March 27, 2015

Ms. Helen Donaldson
Planning and Development Department
City of Portland, Maine
389 Congress Street
Portland, Maine 04101-3509

**Subject: Century Tire Plaza – 195 Kennebec Street
Project ID# 2015-027
Review Comments Received March 24, 2015**

2 | BUILDING A FLOOR PLAN
1/8" = 1'-0"

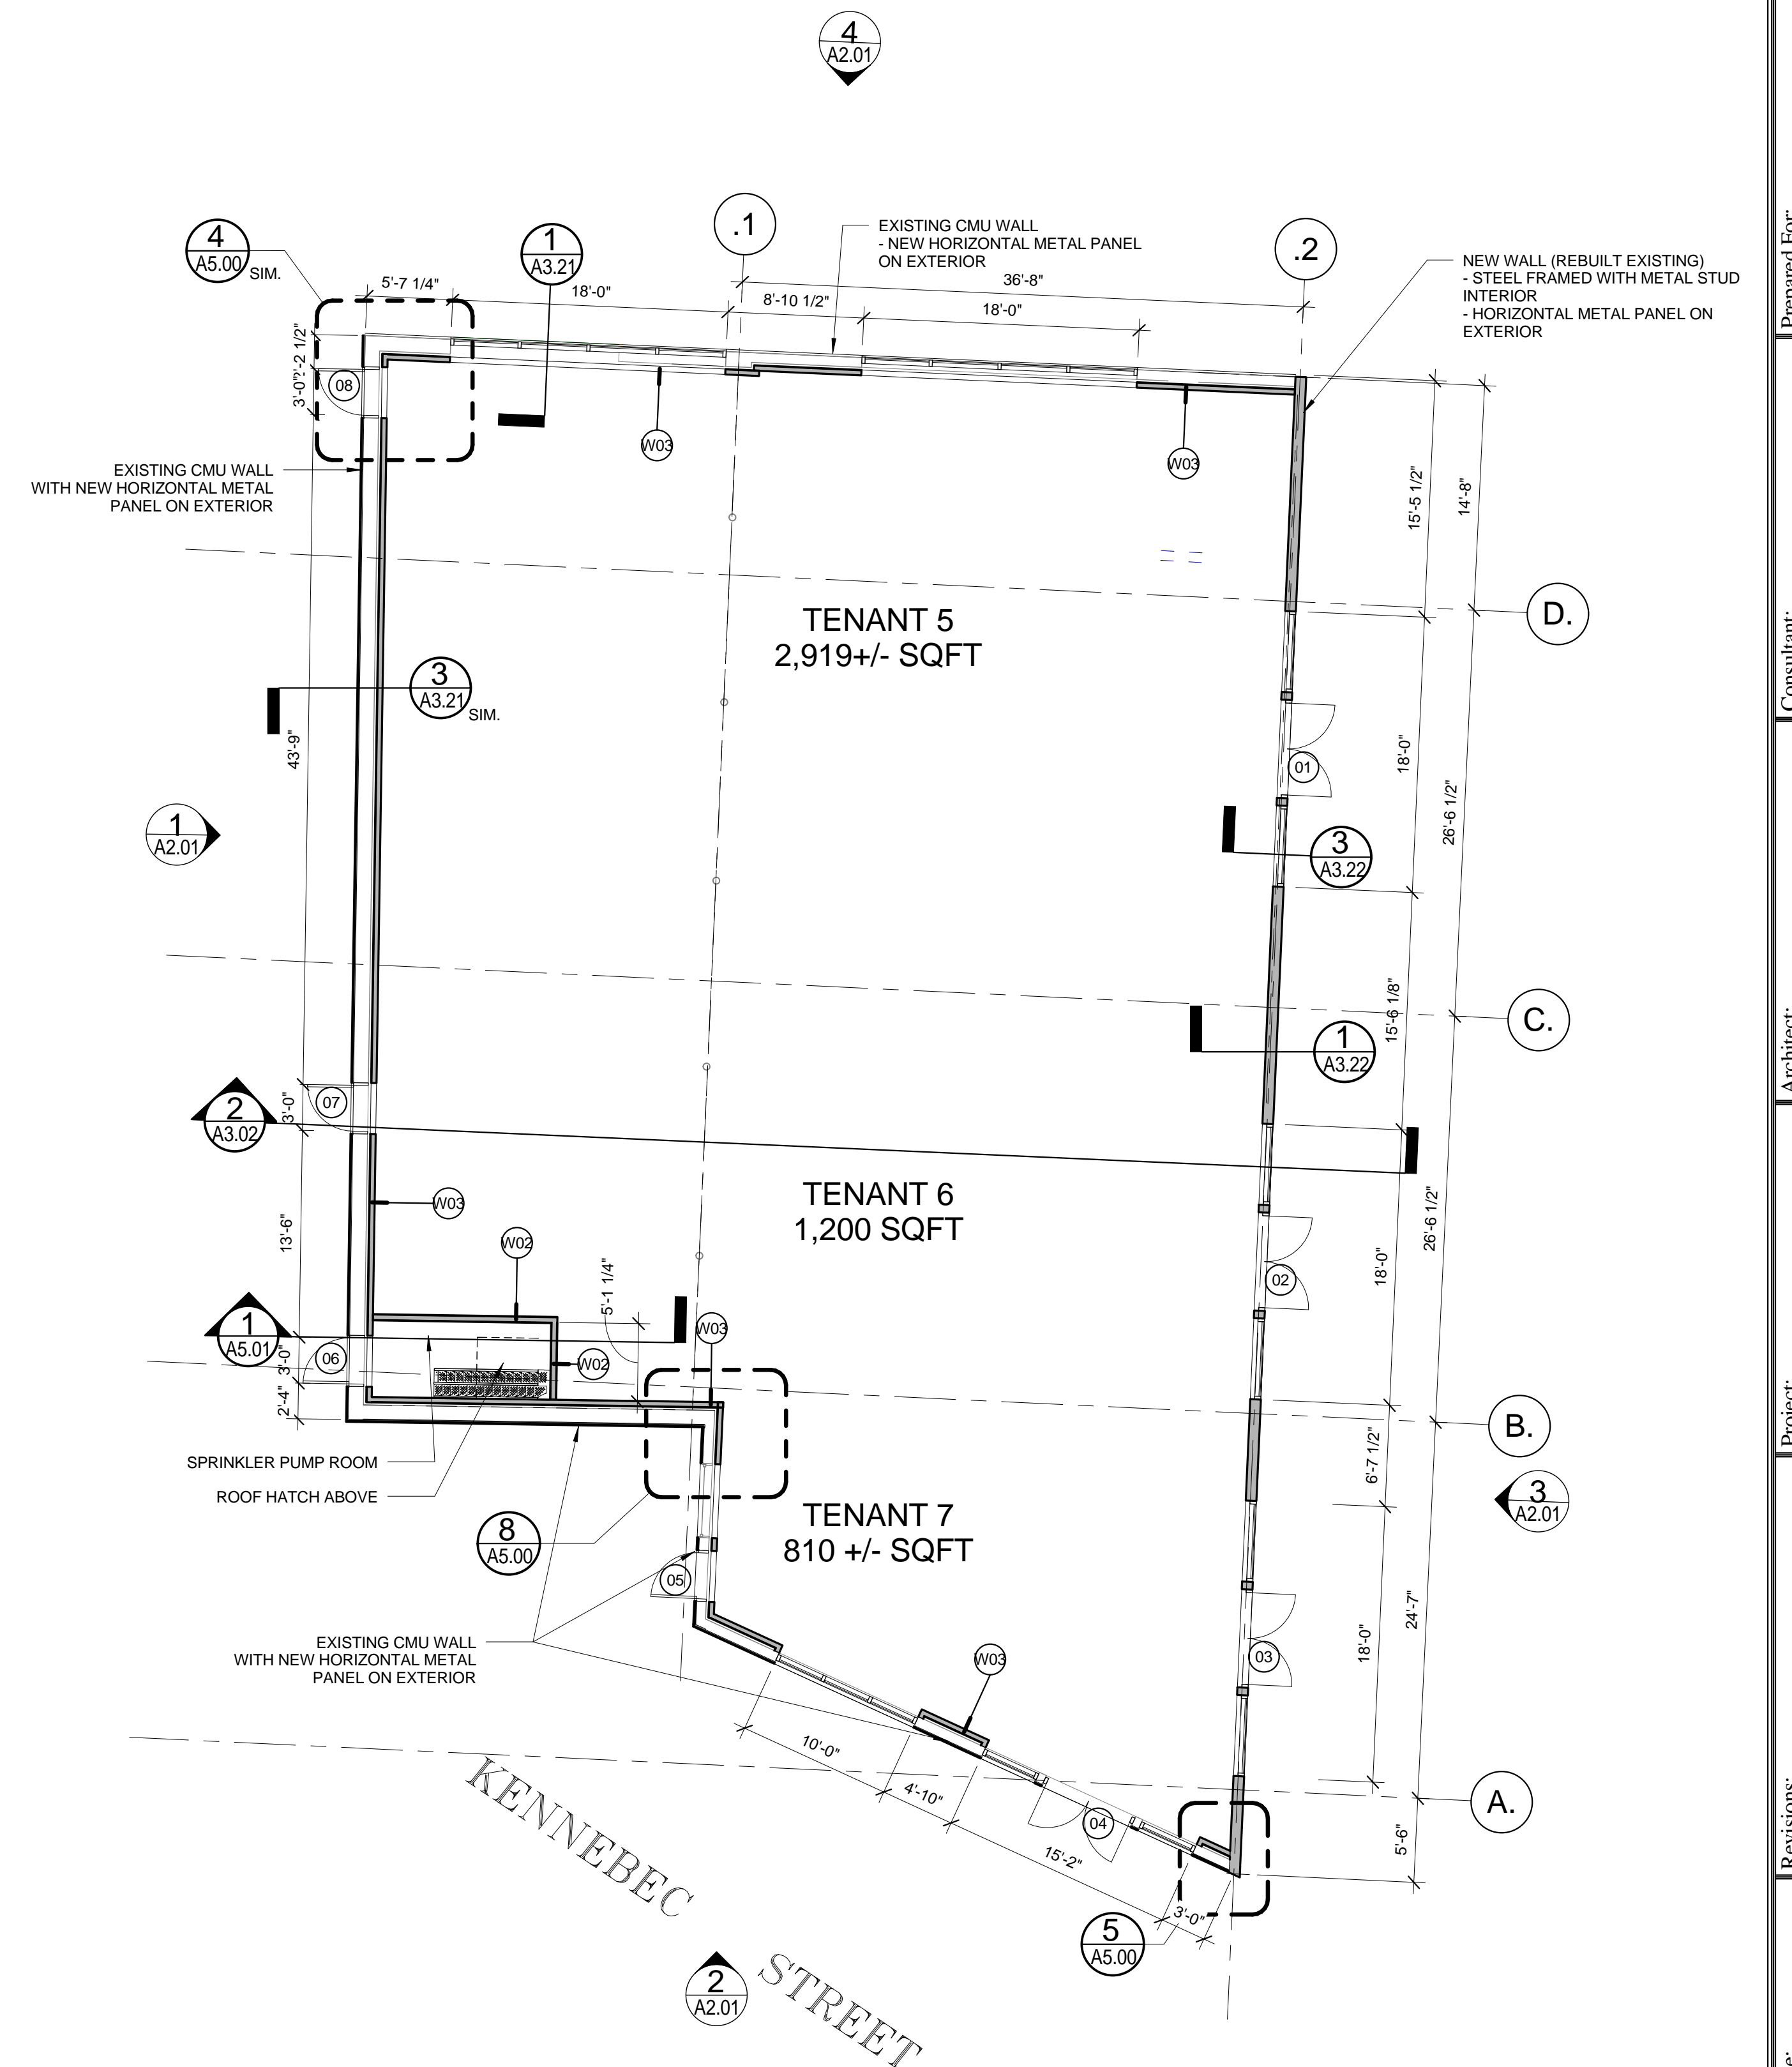
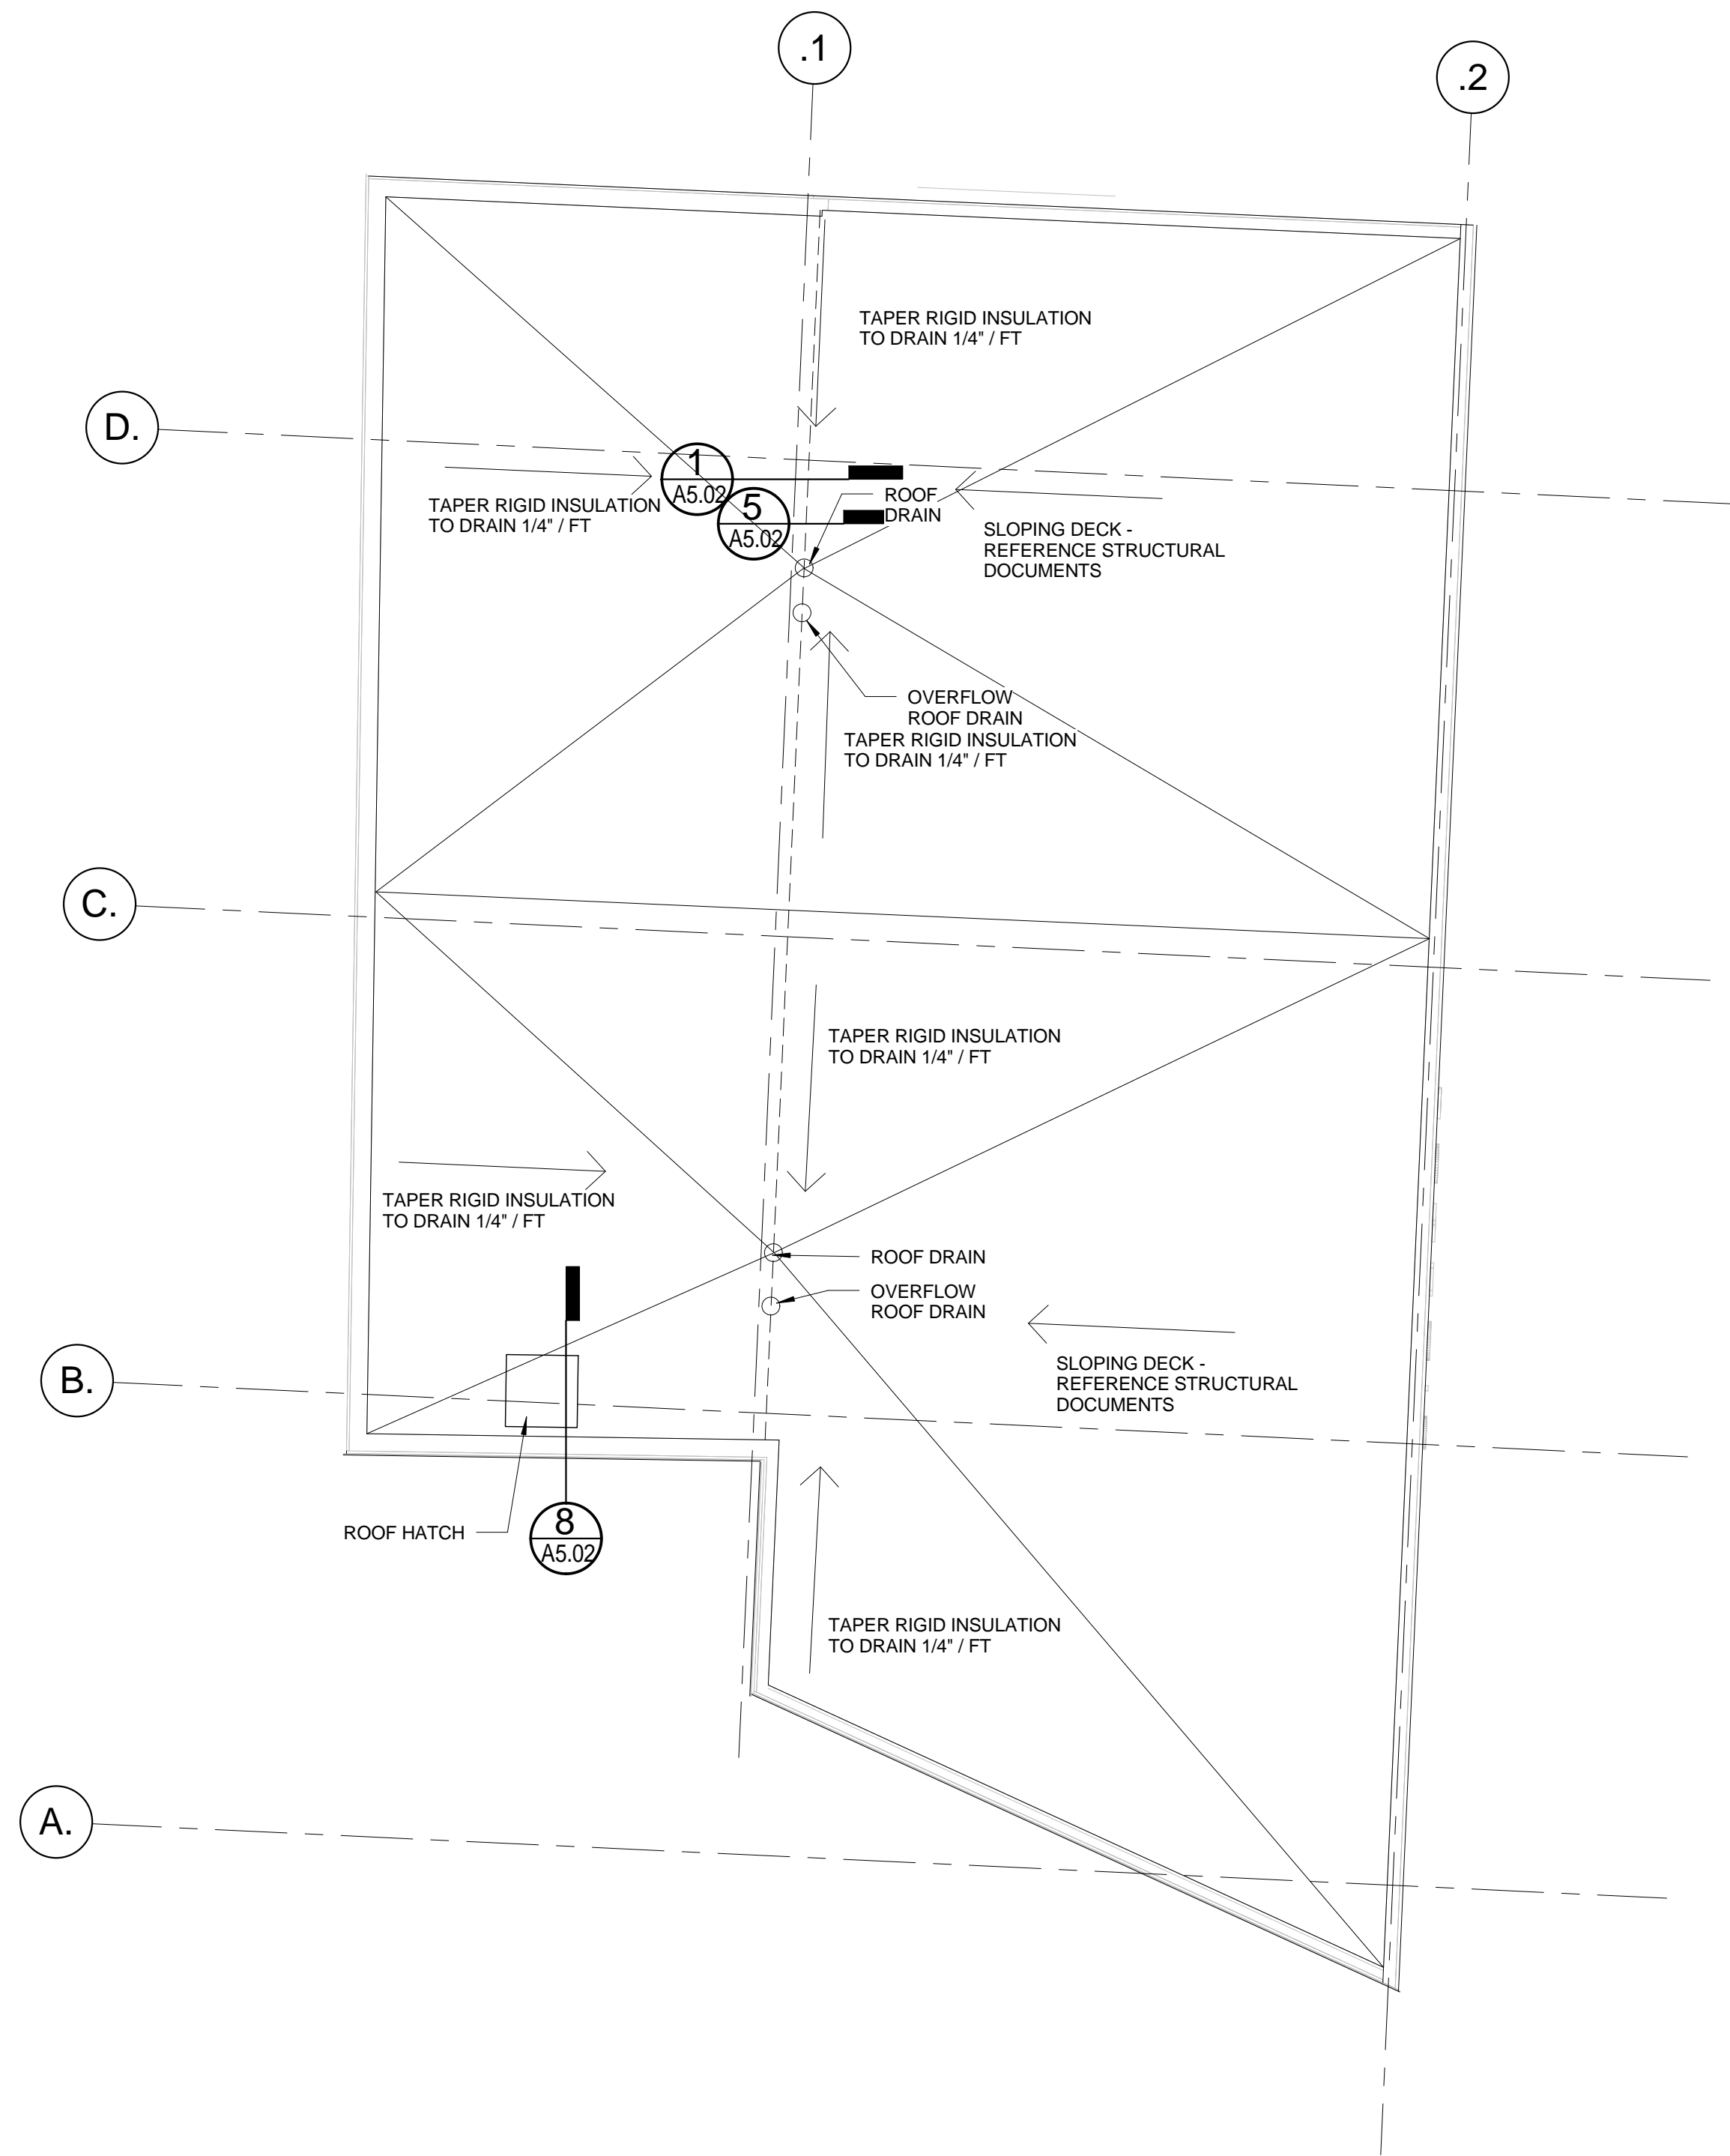
Under Section 14-299(0), the B-7 zone requires that “[a]ll buildings shall have a minimum of one (1) public pedestrian entrance facing the street frontage of the lot.” Given this standard, plans should be revised to show Building A with an entrance on Kennebec Street.

- Building A does not incorporate any elements to enhance the pedestrian environment on Kennebec Street.
- Street lights and street trees are not currently shown in proposal.

- Building A should be revised to orient the primary façade and entrance(s) to the street.

- *Building A should be revised to provide a primary entrance on Kennebec Street.*

The revised Architectural plans show a doorway on the Kennebec Street side of Building A.

An entrance and sidewalk connection has been added at Building A on the side facing Kennebec Street. Street lights and street trees will be shown on the revised Landscape Plan. This will be provided under separate cover. The applicant's representative has scheduled a meeting with Kevin Thomas to finalize details of the street light design. The revised plans will be provided subsequent to this meeting.

This was discussed at the meeting on March 25, 2015 and the plans for Building A have been amended to show a revised façade and an entry on Kennebec Street.

This was discussed at the meeting on March 25, 2015 and the plans for Building A have been amended to show a revised façade and an entry on Kennebec Street.
